Our reference: P-1201940-M8H7
Contact: Tania Shephard
Telephone: (02) 4732 7797

**Council Advice on the Environmental Impact Statement for SSD-123834490
– Grundy's Waste Solutions Resource Recovery Facility at 7 Dunheved Cct,
68 and 72 Links Rd, St Marys**

DRAWING:
 PROPOSED OVERALL SITE PLAN
 SCALE: 1:1000 DATED: 11-11-2005 DRAWN: GUL
 PLOT NO: GWPE-081623 JOB NO: 305 SHEET: A03 OF: B

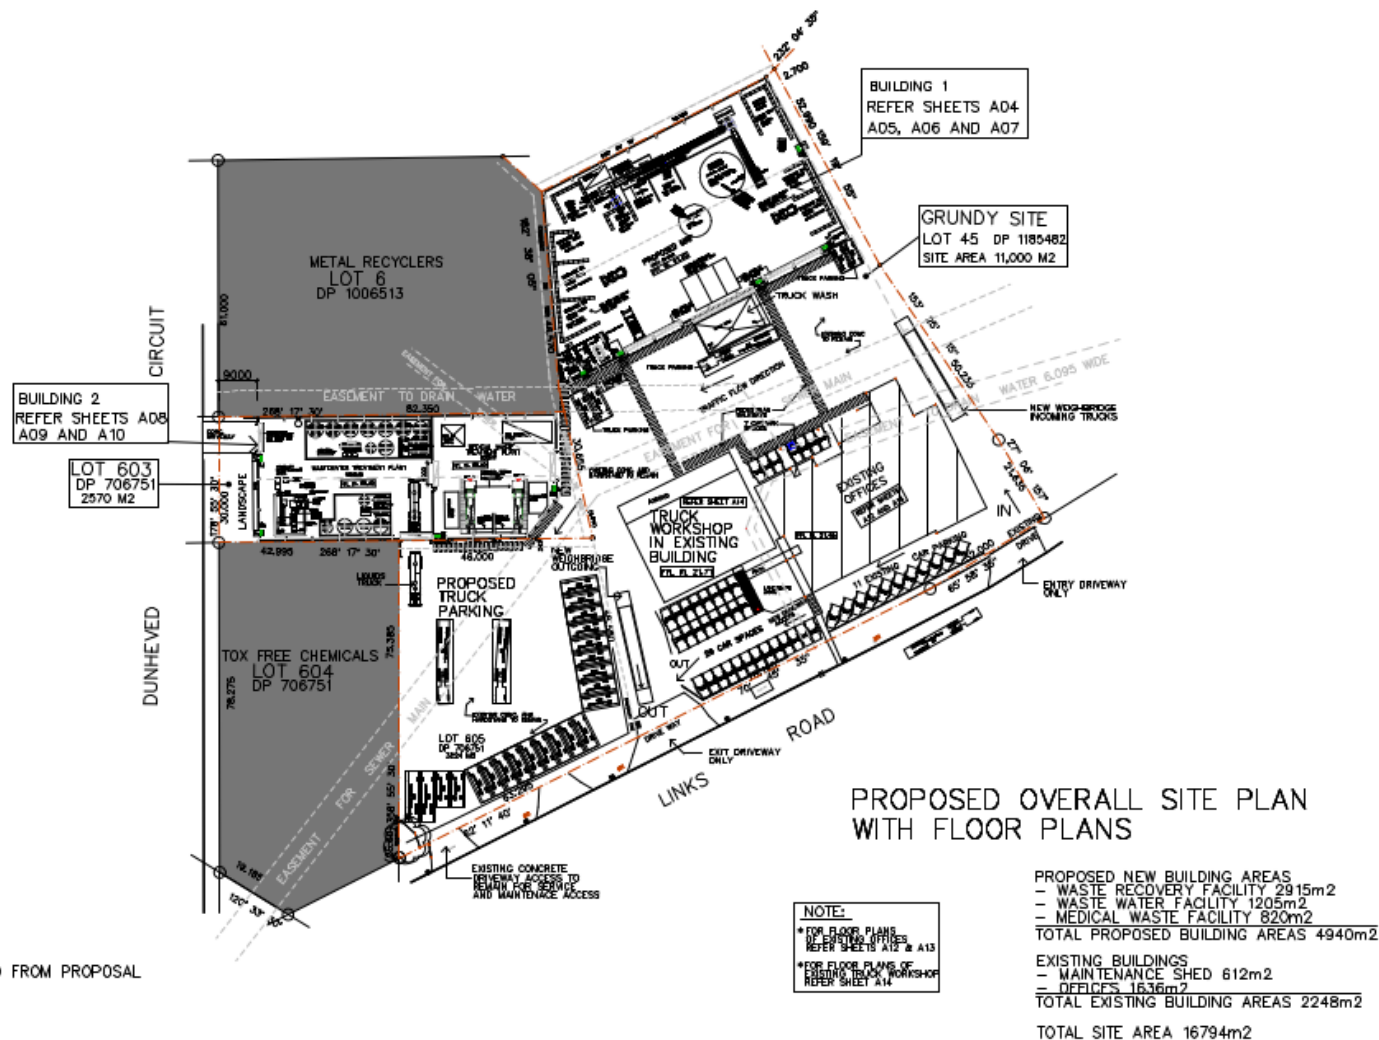
- g) The setback to Dunheved Road is not mentioned in the EIS. Penrith DCP 2014 requires a minimum 9m setback.
- h) Landscaping opportunities are not provided along the Links Road frontage. Section 4.3 of Penrith DCP 2014 outlines controls for setbacks and landscaping aimed at mitigating adverse streetscape and urban heat impacts.

- j) Penrith DCP 2014 outlines requirements for fencing forward of the building line and for the style of fencing, including the provision of barbed wire as is proposed. The consent authority is requested to consider these requirements.
